City of Portland, Maine - Building or Use Permit Application

Location of Construction: 79 Stuart St	Owner Name: Jimino Alphonso &	Owner Address: 79 Stuart St	Phone: 207-878-9746
Business Name: n/a	Contractor Name: no contractor/self	Contractor Address: n/a n/a	Phone:
Lessee/Buyer's Name n/a	Phone: n/a	Permit Type: Additions - Dwellings	Zone: R-3

Proposed Project Description: Build 18' x 26' Garage	Signature:	Signature:
	PEDESTRIAN ACTIVITIES DISTRICT (P.A.D.)	
	Action: <input type="checkbox"/> Approved <input checked="" type="checkbox"/> Approved w/Conditions <input type="checkbox"/> Denied	
	Signature:	Date:

Comments: 79 Stuart St.
12/3/01 Originally denied because of lot coverage - however, homeowner removed the illegal rear 10x14 deck and legalized the shed (see permit #01-1503).

79 Stuart Street  
Portland  
Maine

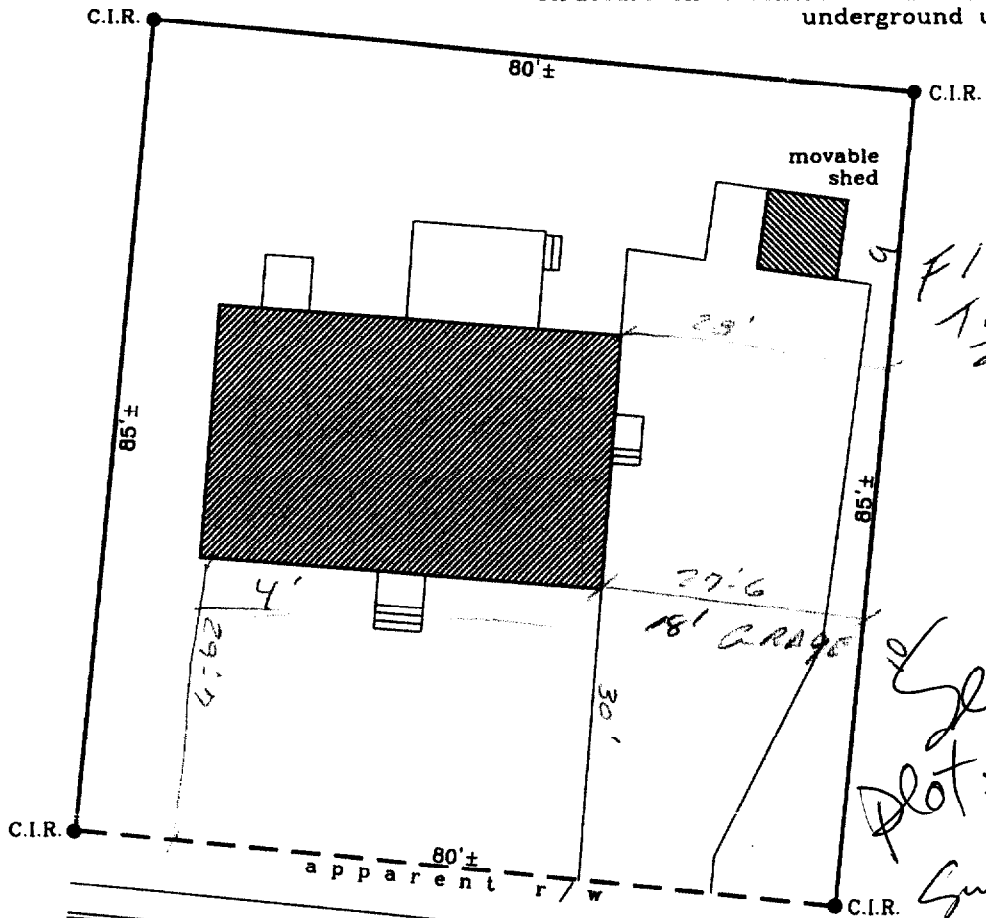
This permit is being issued with the removal of the illegal 10' x 14' rear deck and the legalization of the 8.5' x 8.5' shed. Please note that with the erection of this 18' x 26' garage, you are at your maximum lot coverage allowance for this zone (R-3 at 25%).
